Our ref: DOC21/583607

Senders ref: SSI 10049

**Subject: Exhibition – Environmental Impact Statement for the Kamay Ferry Wharf Project (SSI-10049) and bilateral assessment**

## Attachment – EES comments on the Environmental Impact Statement for the Kamay Ferry Wharf Project (SSI-10049)

Figure 11-8: TECs at Kurnell

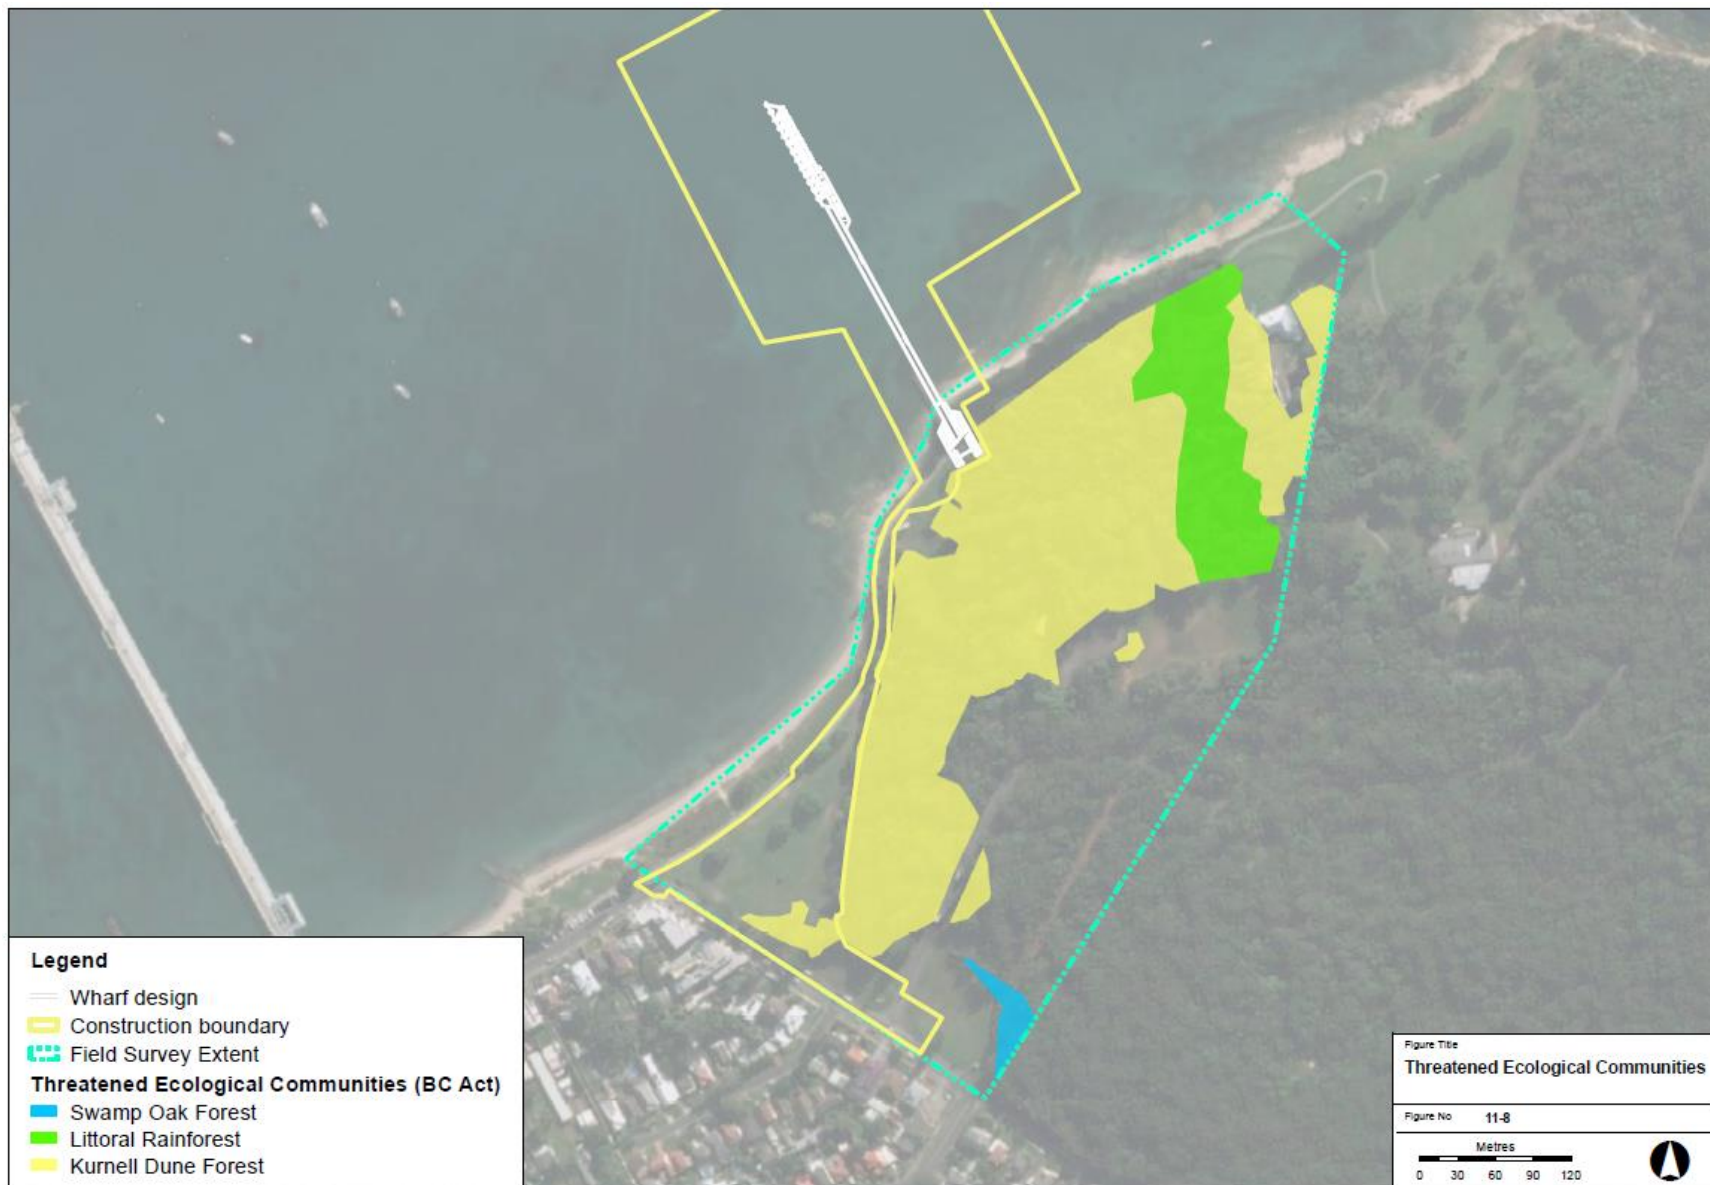
- The amount of vegetation stated to be cleared in the assessment for EPBC Act matters of national environmental significance (MNES) – 0.29ha, e.g. in section 5.2.3 and on page 3 of the executive summary – is inconsistent with the amount stated in the BAM assessment – 0.06ha, e.g. in Table 6-2 and page 3 of the executive summary. Similar contradictions pertain to the stated amounts of clearing of habitat of certain species credit species – Large-eared Pied Bat and Grey-headed Flying-fox. Values stated in Chapter 11 of the EIS are consistent with the BAM assessment.

EES notes that there are inconsistencies in the description of the amount of vegetation to be cleared in the EPBC Act MNES assessment compared to figures in the BAM. Section 5.2.3 states that 0.29ha is to be cleared, but Table 6-2 states 0.06ha is to be cleared. There are also inconsistencies in the stated amounts of clearing of habitat for the Grey-headed Flying-fox.

Figure 5-5: Kurnell wharf design features

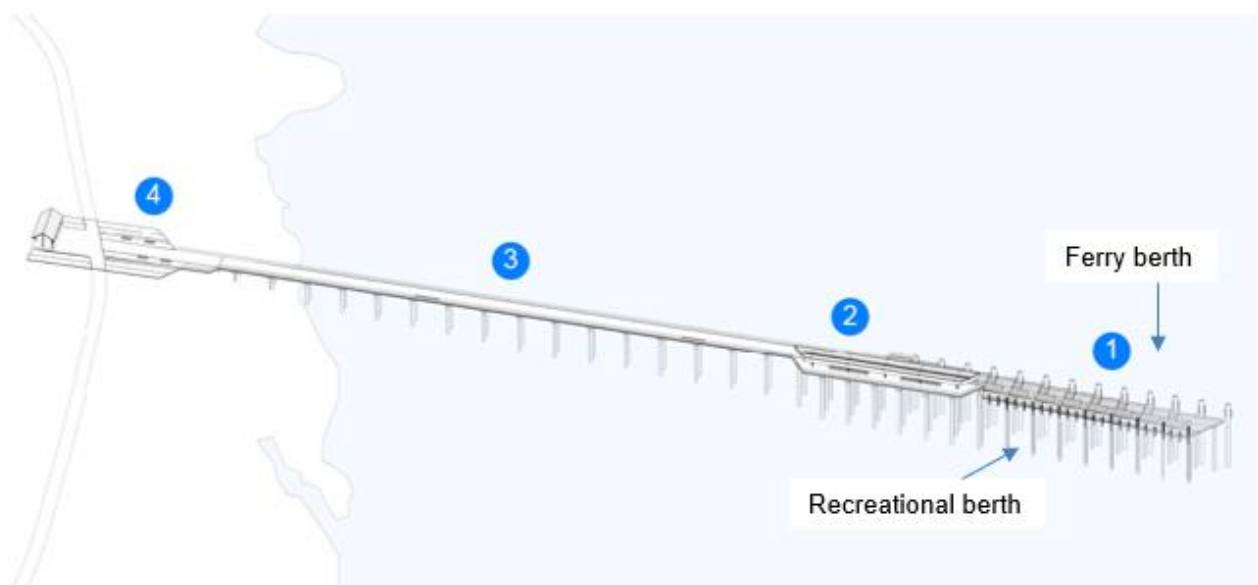
It is requested that consideration be given to identification of alternative locations for the installation of the Kurnell services cabinet to reduce impacts to the heritage landscape. Its height of 1200mm in such a prominent location could be detrimental to the sight lines and broader heritage landscape.
